To: South Holland District Council

Application Ref: H16-0515-25

Proposal: **Residential development of 76 dwellings and associated infrastructure**

Location: **Land at Horseshoe Road, Spalding, PE11 3JB**

House Type - Maisonette`s (S103 & S104)

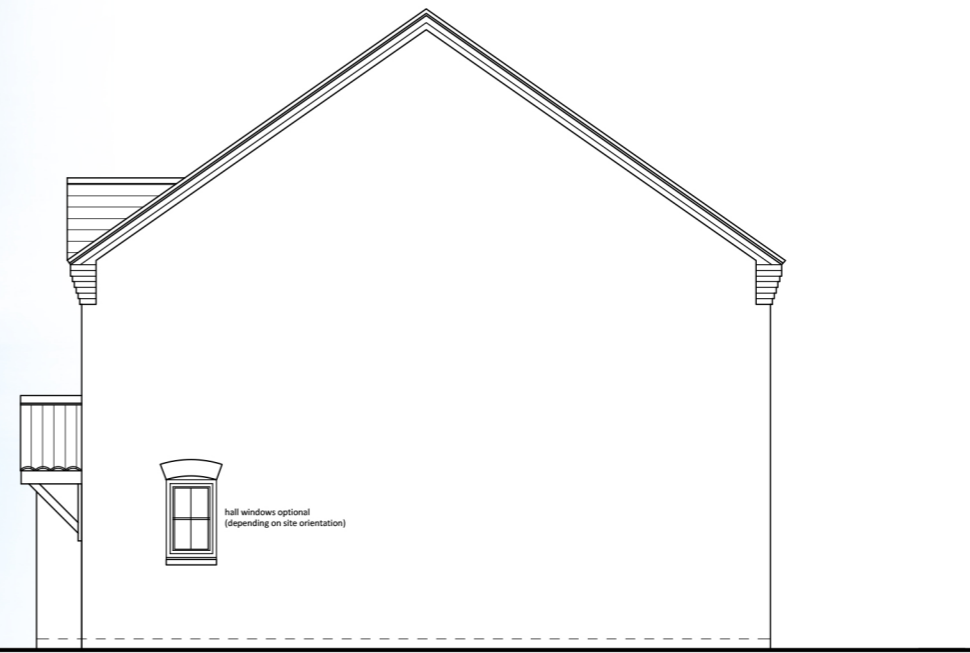
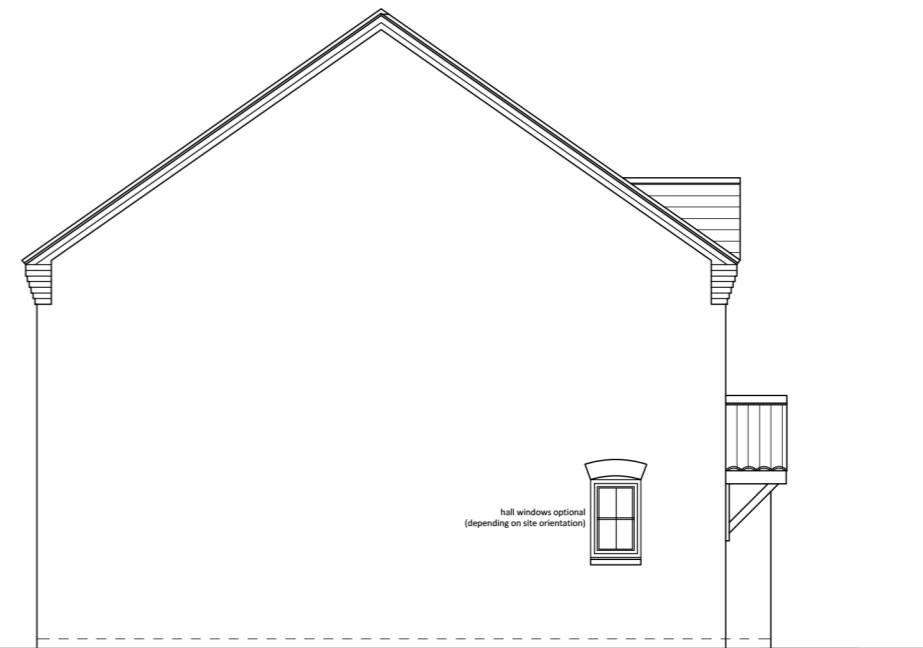
- Parking for plots 39 & 38, 66 and the maisonettes will not work – residents will park on the road for convenience.
- The large footway expanse at the junction is unnecessary – it should be reduced and street trees incorporated.
